From: Laura Hutson [REDACTED]
Sent: 11 January 2018 14:52
To: Planning.Responses
Subject: App Ref: FG/174/17/PL - Little Twitten Recreation Ground - Sport England Ref: SE/AR/2017/47692/S

On land adjacent to the recreation ground it is proposed to add an additional four houses to a plot currently containing one existing house. As this plot is adjacent to the recreation ground currently used by a cricket club, there is the possibility that these new houses may prejudice the playing field were they to be struck by cricket balls.

DRAWING TITLE
Proposed Site Plan, Location Plan
and elevation from south

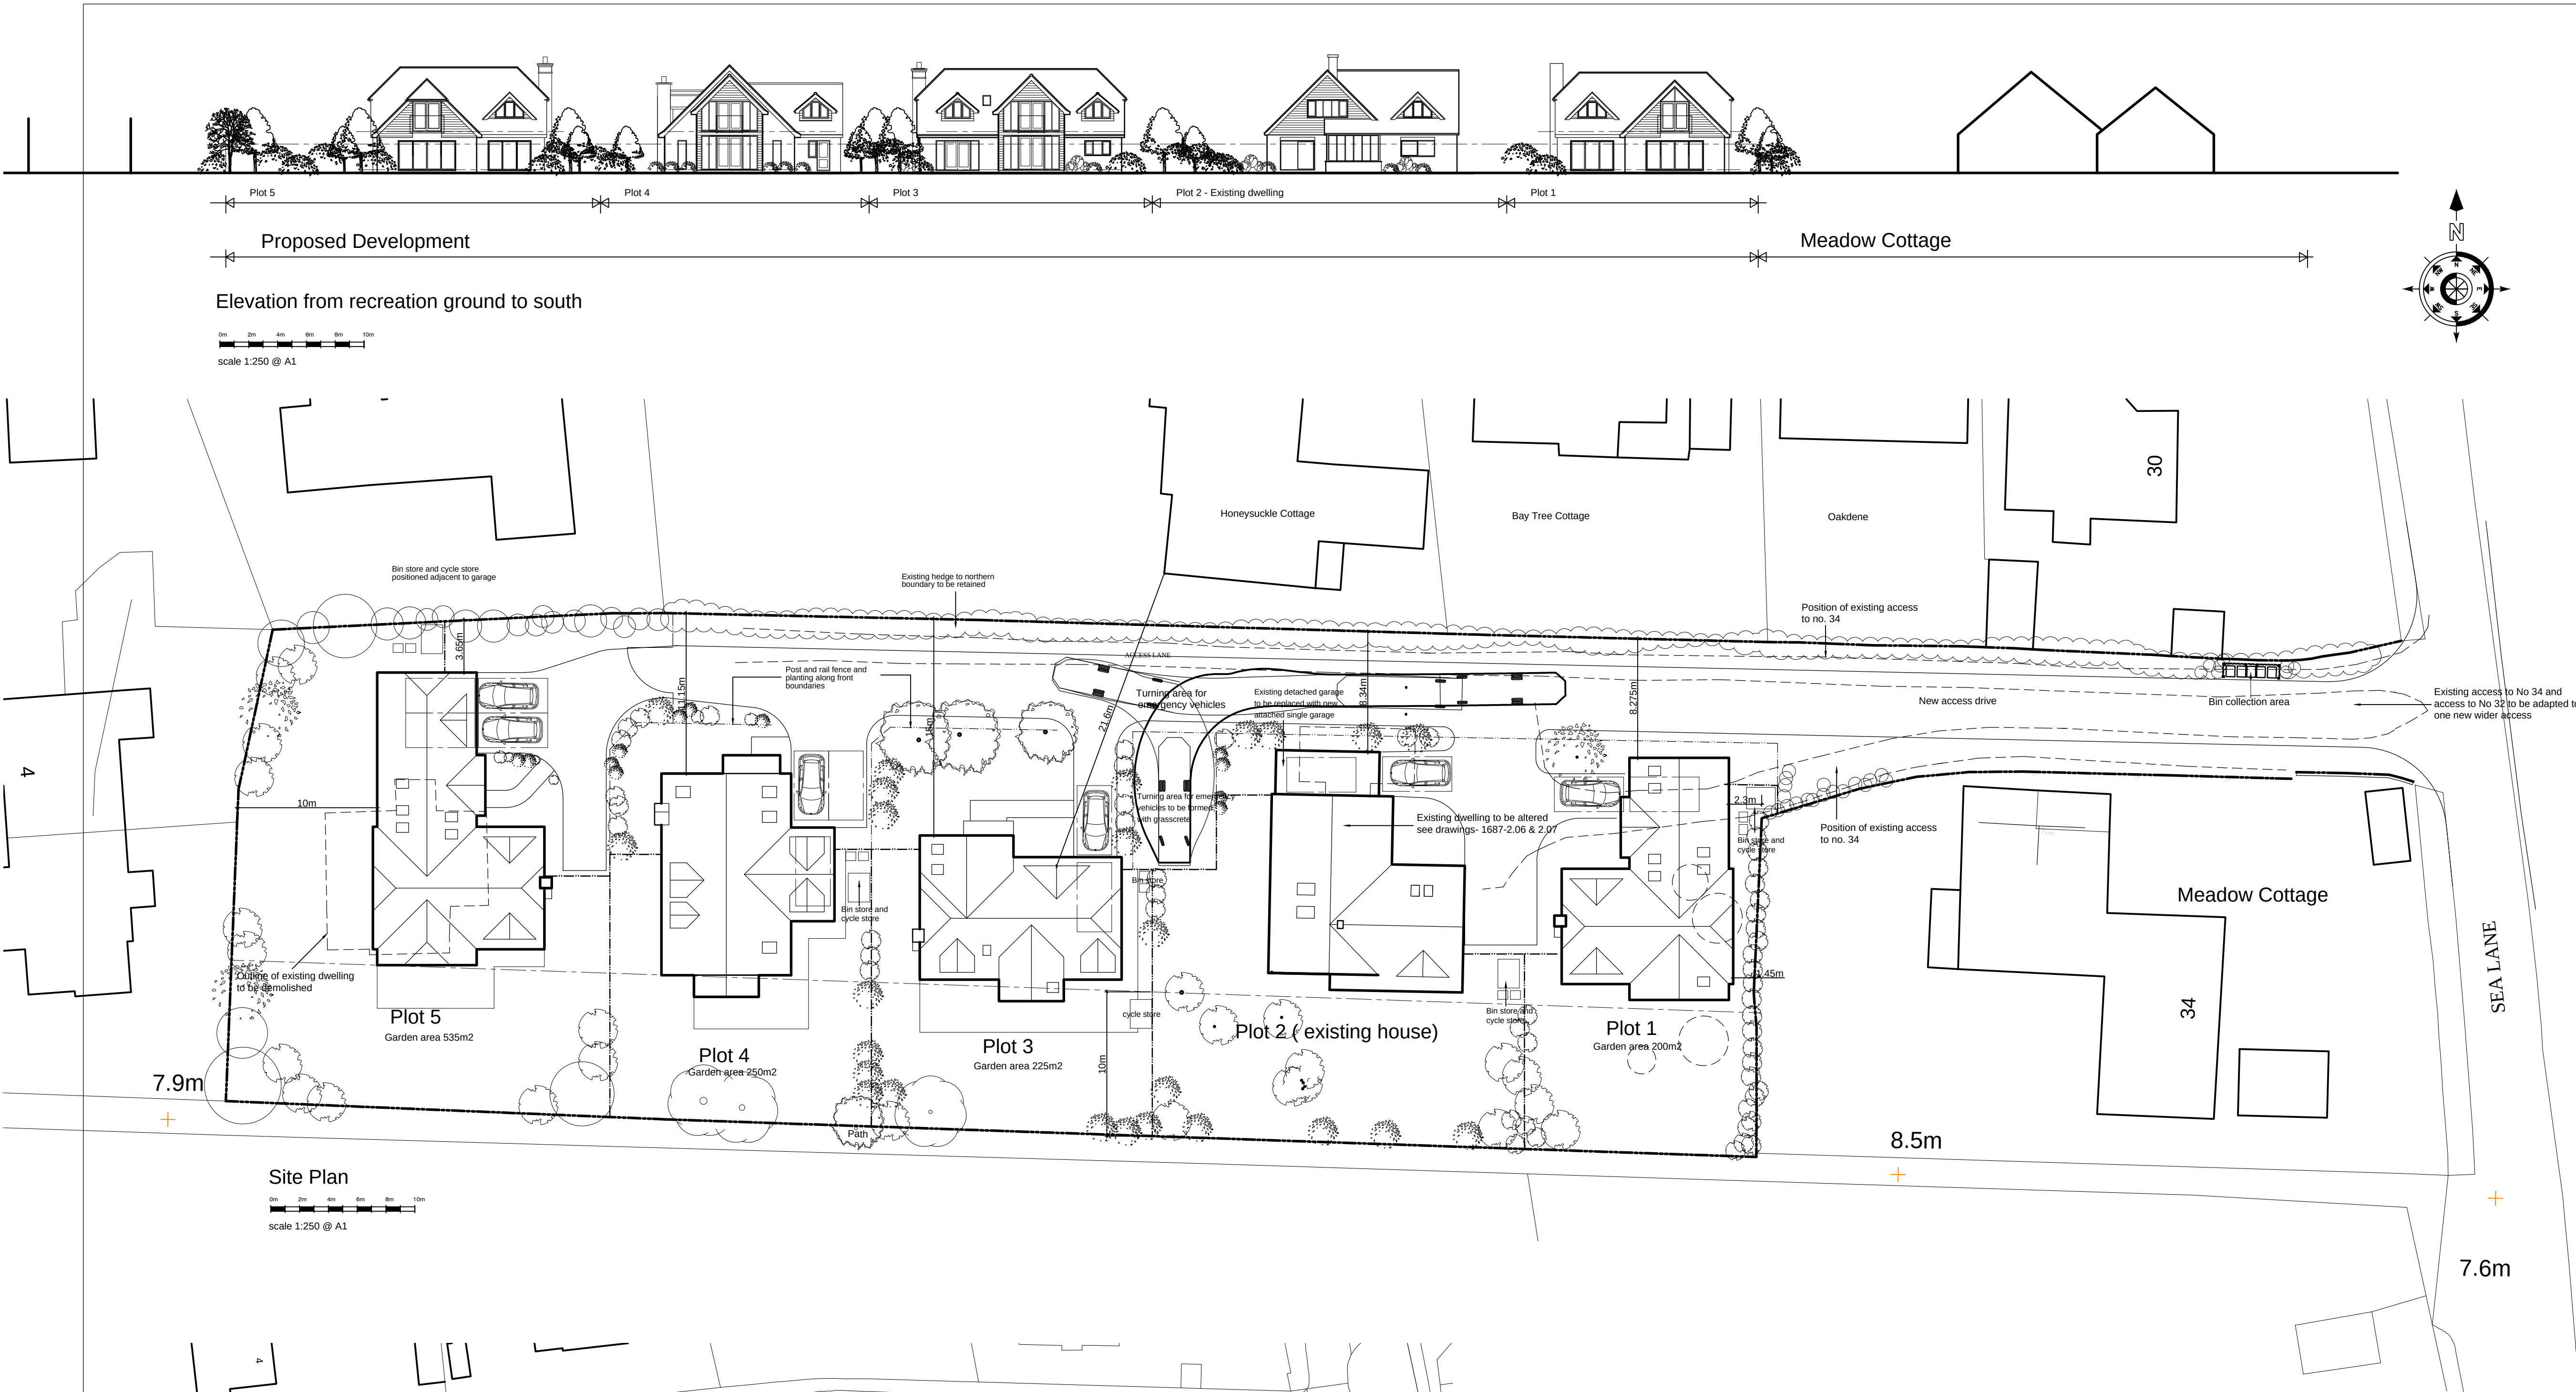
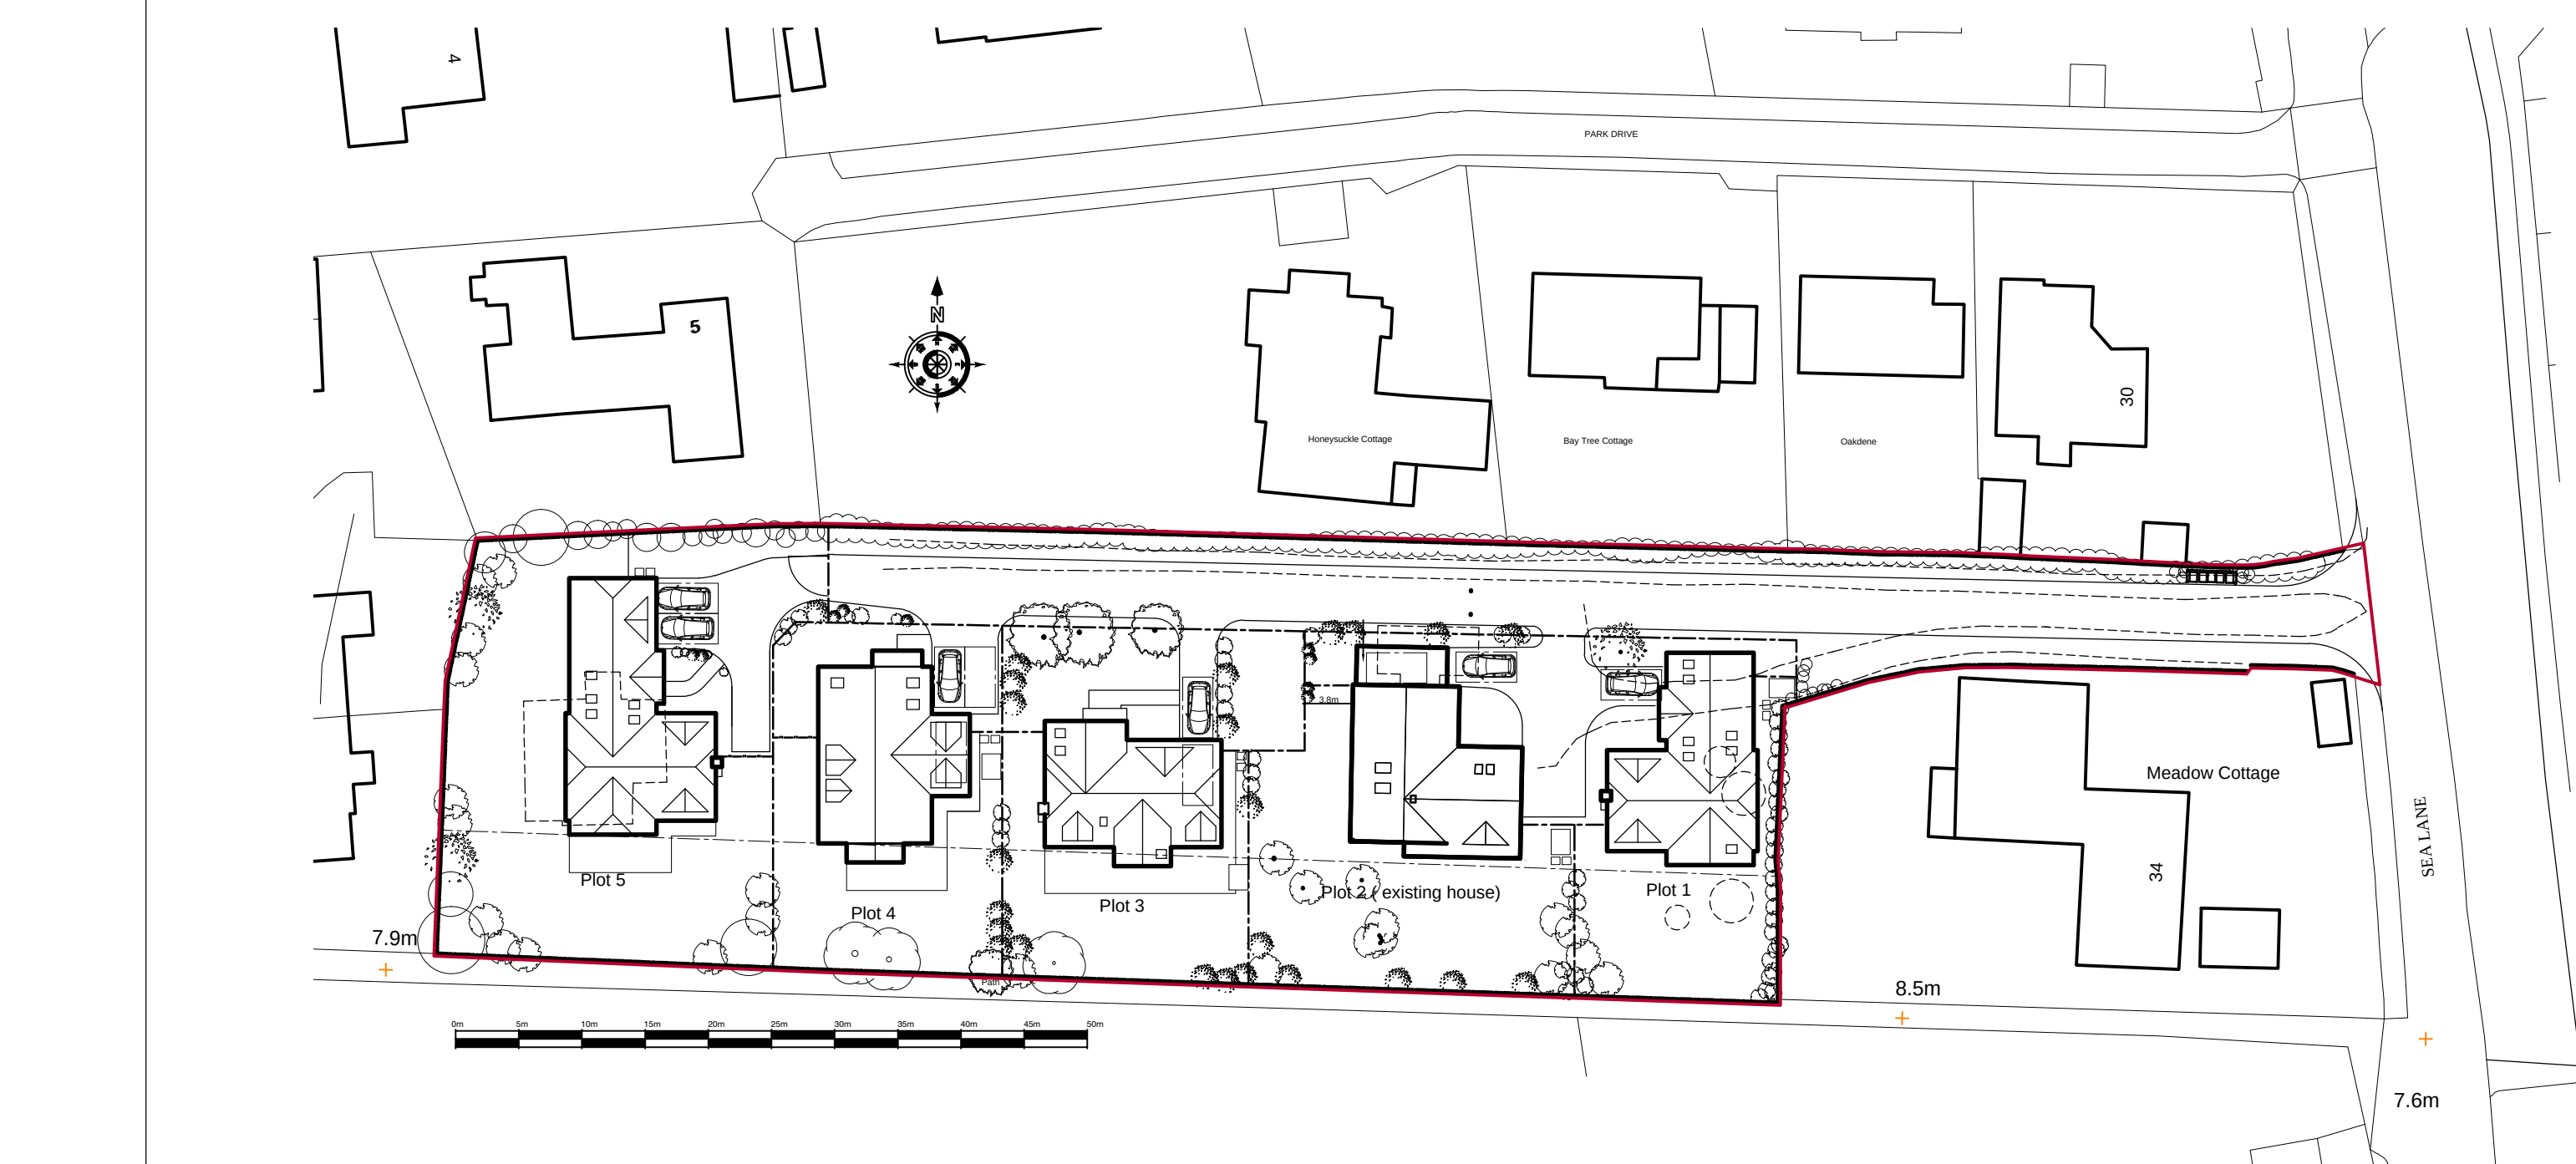
It is noted that the houses are part of an existing development; however there may be the potential for these additional houses to increase the risk of ball strike and therefore prejudice the playing field.

I therefore consulted the ECB, who stated that the cricket club in question are concerned about ball strike and the potential for damage and injury from the proposed development. The ECB states that the proposal will mean that the new properties will be closer to the playing area than the existing dwelling and as such there may be an increased risk of ball strike. The ECB recommends that a detailed risk assessment be undertaken by Labosport (www.labosport.com) and that the costs of installing any mitigating recommendations resulting from the Labosport report be met by the applicant.

In light of the above, Sport England **objects** to the application because it is not considered to accord with any of the exceptions to Sport England's Playing Fields Policy or with Paragraph 74 of the NPPF. However, should a ballstrike assessment be undertaken and any appropriate mitigation undertaken, Sport England would be happy to reconsider its position.
